August 20, 2024

**Re: Event Center at 1611 Airtech Ct. SE
Erosion and Sediment Control Plan
Engineer's Stamp is not legible (N15E017)**

Based on the information in your submittal received on 8/12/24, the above-referenced ESC Plan can't be approved until the following comments are addressed.

Landscape Plan

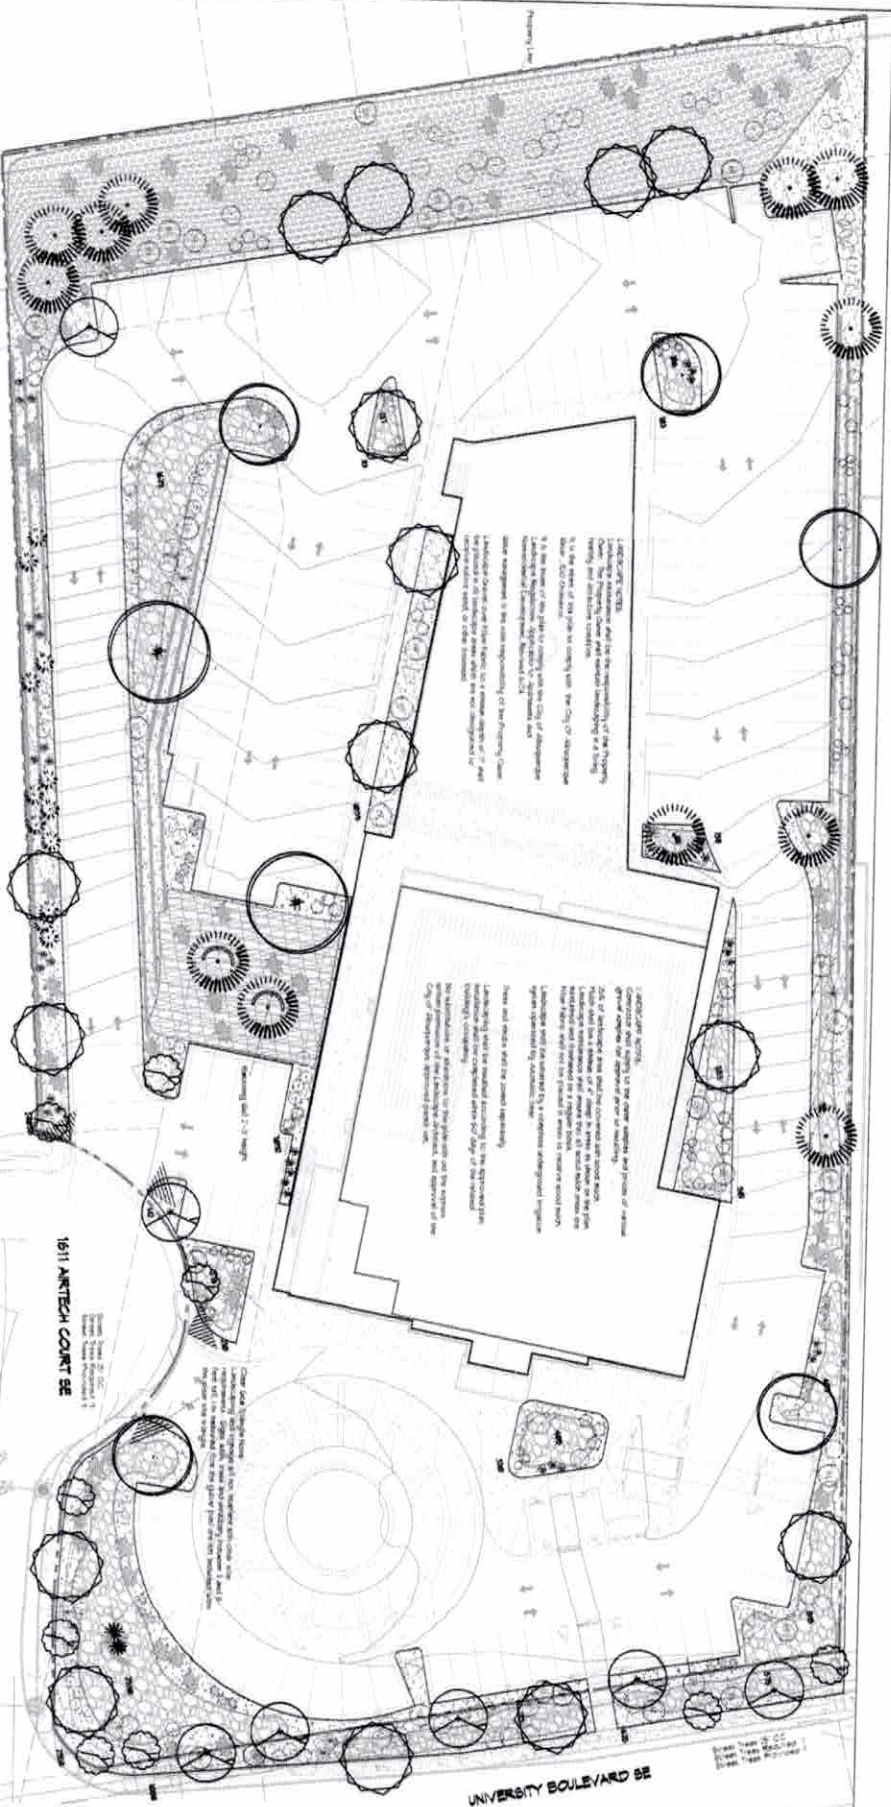
2. The ESC Plan is fuzzy and hard to read. The engineer's stamp is illegible and missing from some sheets. The Landscape sheets should be submitted separately for information only and should not be included in the ESC Plan set. The sheets are 8.5" x 11", but the required size is 22" x 34". All sheets in the ESC Plan sets must be on a standard-size sheet with a standard border and title block as required by the drafting standards in the city's Development Process Manual (DPM) Part 4-2, and templates are at https://documents.cabq.gov/planning/DevelopmentReviewServices/DRC/CABQ_Title_Block.dwg. Lettering size and sheet numbering must be per city standards.
